# Norfolk Boreas Offshore Wind Farm

# Applicant's response

Applicant: Norfolk Boreas Limited  
Document Reference: ExA.OFH1.D1.V1  
Deadline 1

Date: November 2019  
Revision: Version 1  
Author: Womble Bond Dickinson

Title:  
Scenario 1  
Viewpoint 11:  
Hale Road, East of Holme Hale Hall

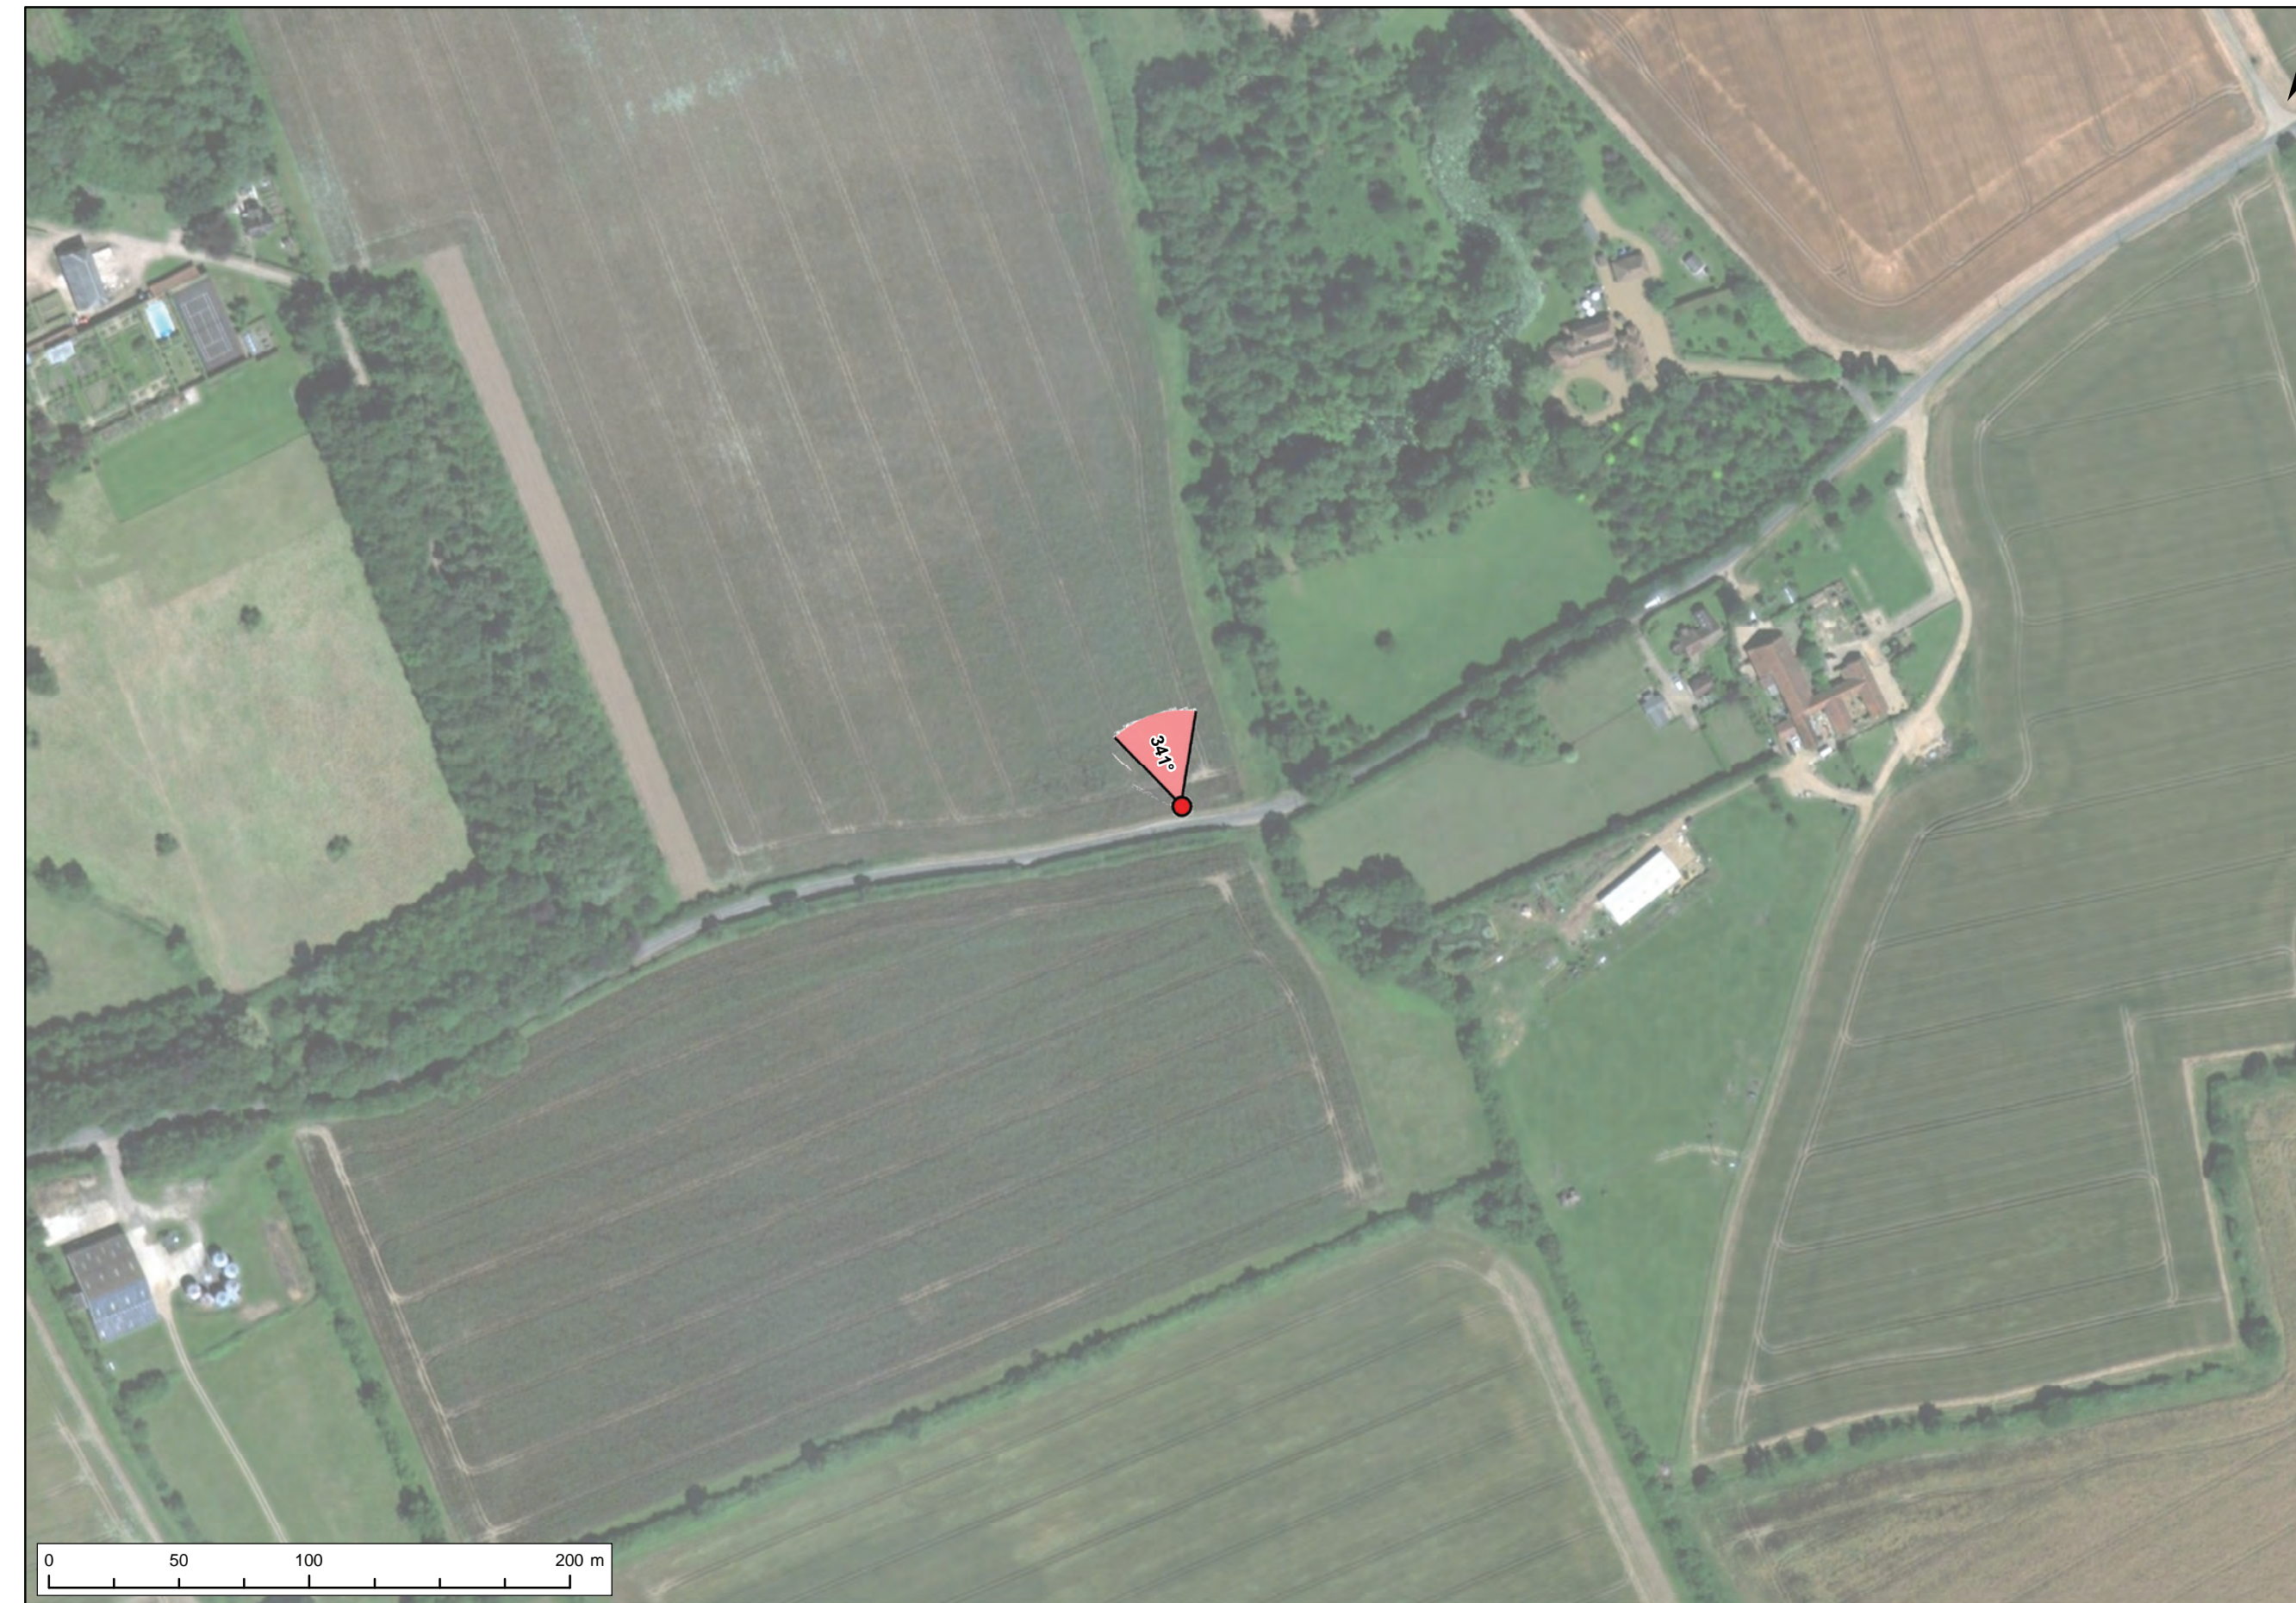
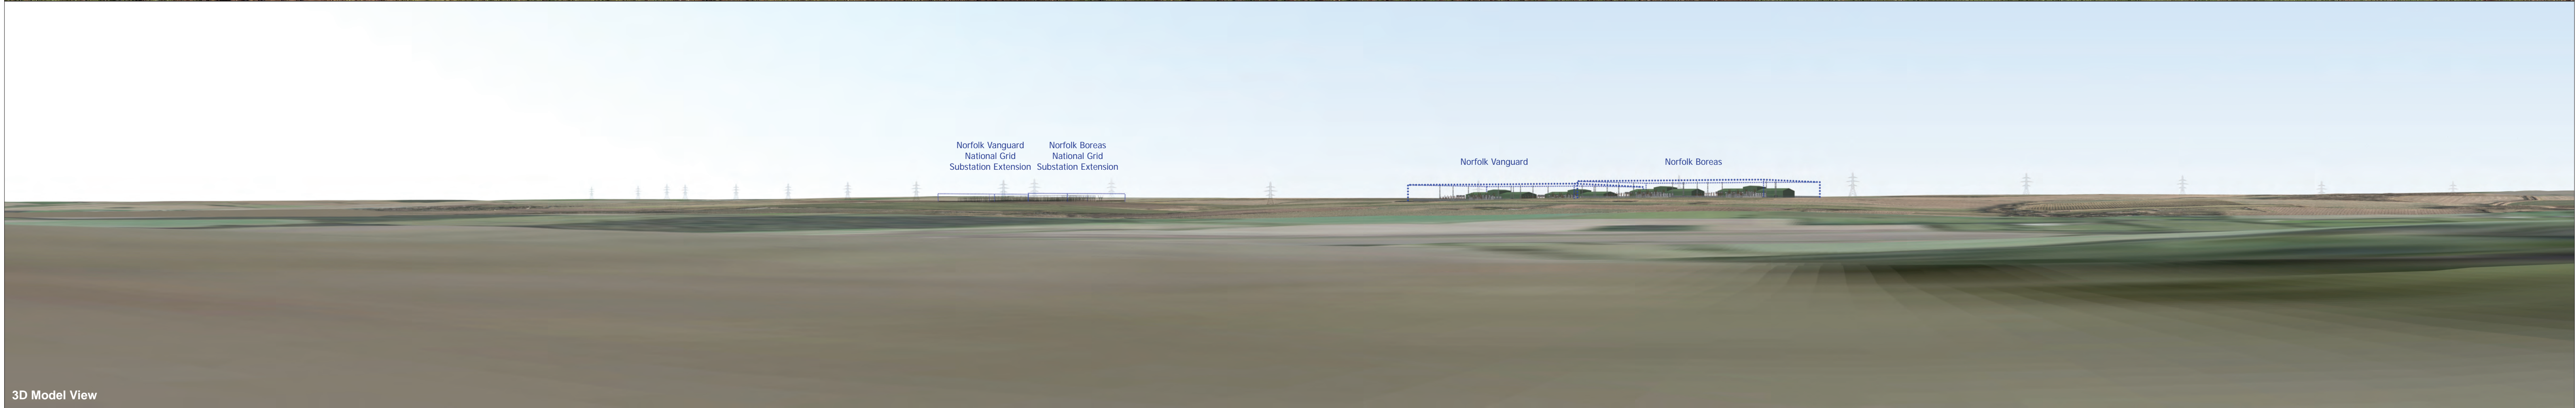
3.	<p><b>Design of Onshore Connection Point</b></p> <p><i>Some Interested Parties (in particular Holme Hale Parish Council) raised concerns in respect of the Horlock Rules and made reference to Policy EN-1. A request was made that more detail be given on design now.</i></p>	<p>The final design of the onshore project substation and National Grid substation extension are subject to detailed design post-consent. In order to minimise visual impacts as far as possible, the appropriate building design and materials will be considered, to ensure blending with the local environment and minimisation of impacts as far as possible. The Design and Access Statement (document 8.3, APP-694) includes a set of Design Principles for the onshore project substation and National Grid substation extension (Table 4.3) which will set out the process to develop the final design.</p> <p>As the final design is not yet known, the environmental impact assessments have been conducted on the basis of a 'Rochdale Envelope' series of maximum extents of the project, with which the significant effects are established. These maximum extents which define the significant effects are secured in the dDCO under Requirement 16, namely the total number of buildings housing the principal electrical equipment, height, width and length of such buildings, maximum height of external electrical equipment and maximum fenced compound areas.</p>

Figure 1-1: Potential landfall locations for the Norfolk Vanguard and Norfolk Boreas offshore wind farm export cables.

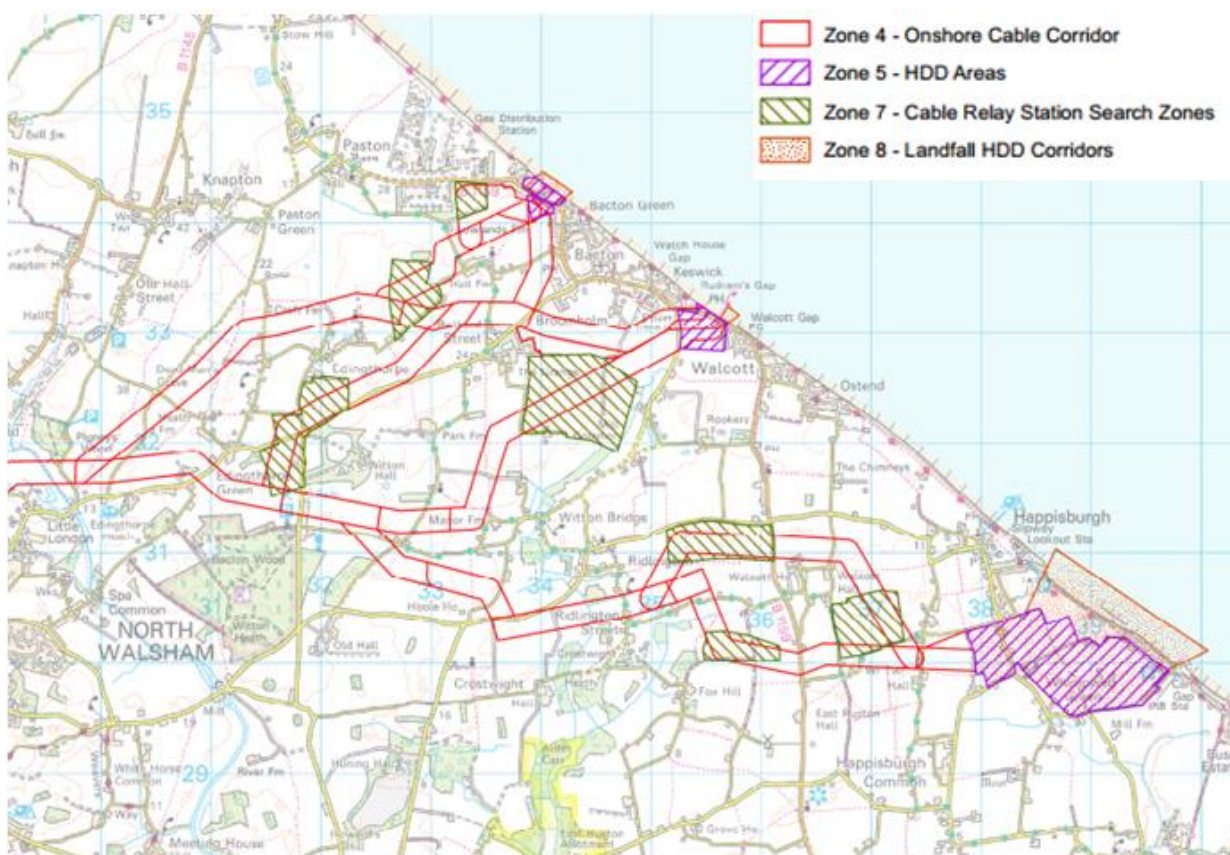
include enhanced thermal conductivity backfill to reduce any potential future thermal interactions with the second project.
16.	<p><b>Landfall and Coastal Erosion</b></p> <p><i>Happisburgh Parish Council, in particular, expressed concern with coastal erosion together with the suitability of Horizontal Directional Drilling at the landfall (including the associated impacts of 24 hour working at the landfall).</i></p>	<p>The Applicant provided a response to these concerns in its Comments on relevant representations (AS-024). Specifically, Table 1 items 1 and 2, and Table 2 item 1. The Applicant will provide a landfall clarification note which will be submitted as part of the Examination to provide further details regarding the landfall method and suitability.</p> <p>In summary, the landfall entry point will be set back from the existing cliff-line by at least 125m to ensure natural coastal erosion will not affect the drilled cable or transition pits within the conceivable lifetime of the project (approx. 30 years). Furthermore, the landfall compound zone extends a further 200m inland, to allow further flexibility in the siting of the landfall post consent, using the most up to date information and forecasts. This is considered embedded mitigation by design to ensure that the landfall cable ducts do not become exposed under a worst case scenario during the project lifetime.</p> <p>In addition, the Applicant has committed to a long horizontal directional drill to avoid any interaction with intertidal areas. A SoCG has been prepared with Natural England (a version of this was submitted in response to the Rule 6 letter on 4<sup>th</sup> November (AS-028)) and North Norfolk District Council (a version of which will be submitted at Deadline 2) which include matters of agreement relating to coastal erosion.</p>
